WEST SUSSEX COUNTY COUNCIL CONSULTATION

TO:	Arun District Council FAO:Michael Eastham
FROM:	WSCC - Highways Authority
DATE:	26 November 2020
LOCATION:	Land South of Water Lane Angmering
SUBJECT:	A/179/20/RES Approval of reserved matters (appearance, layout & scale of access only) following A/99/17/OUT for a culvert & associated access over the Black Ditch providing access to the approved development. This application may affect the setting of a listed building & falls within Strategic Site SD9, CIL Zone 1 (Zero Rated).
DATE OF SITE VISIT:	n/a
RECOMMENDATION:	More Information
S106 CONTRIBUTION TOTAL:	n/a

WATER LANE, ANGMERING PROPOSED ACCESS PROPOSED CONTOURS

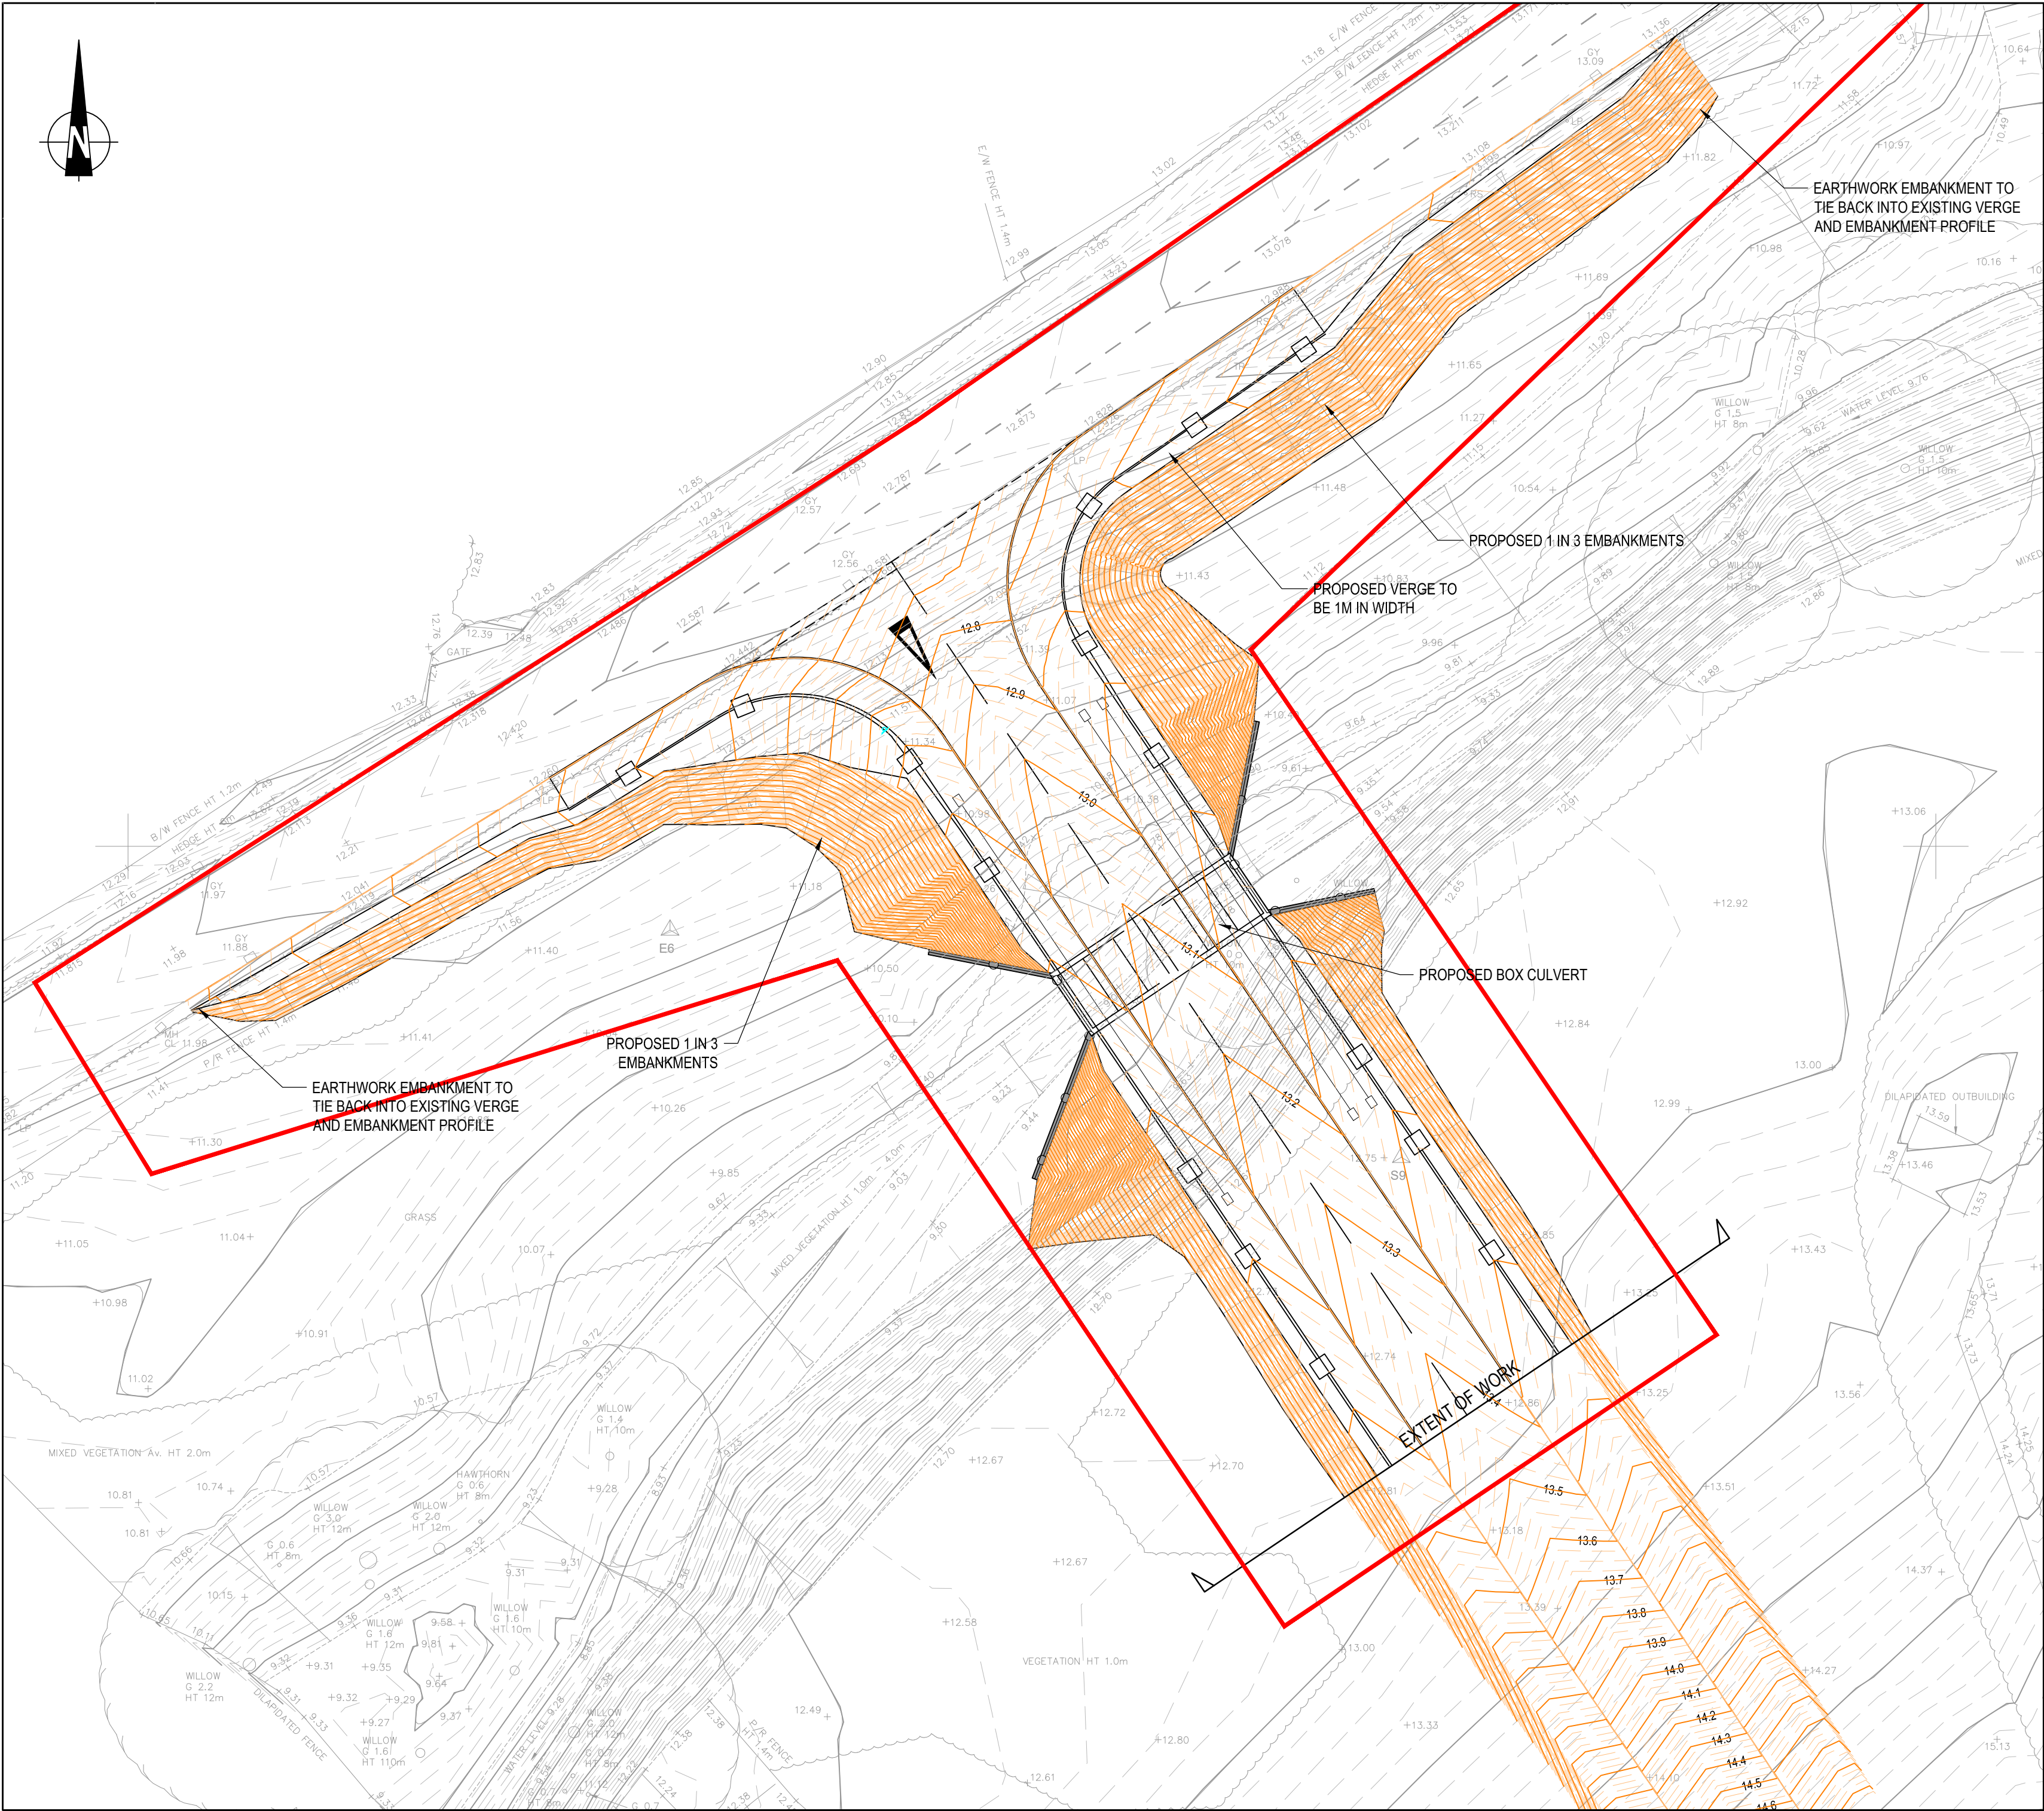
Notwithstanding the above, it's noted that the footway and cycleway crossing the culvert are on the opposite sides of the carriageway compared with the layout presented as part of the permitted outline application. This isn't an issue with the current layouts being consistent with the reserved matters application running currently for the remainder of the on-site layout. The outline application did however indicate a crossing over Water Lane connecting into another foot/cycle way running to the north and east. It would be beneficial for the Water Lane crossing and onward connections to be indicated on the plans even if these are to be provided as part of a different phase of the development.
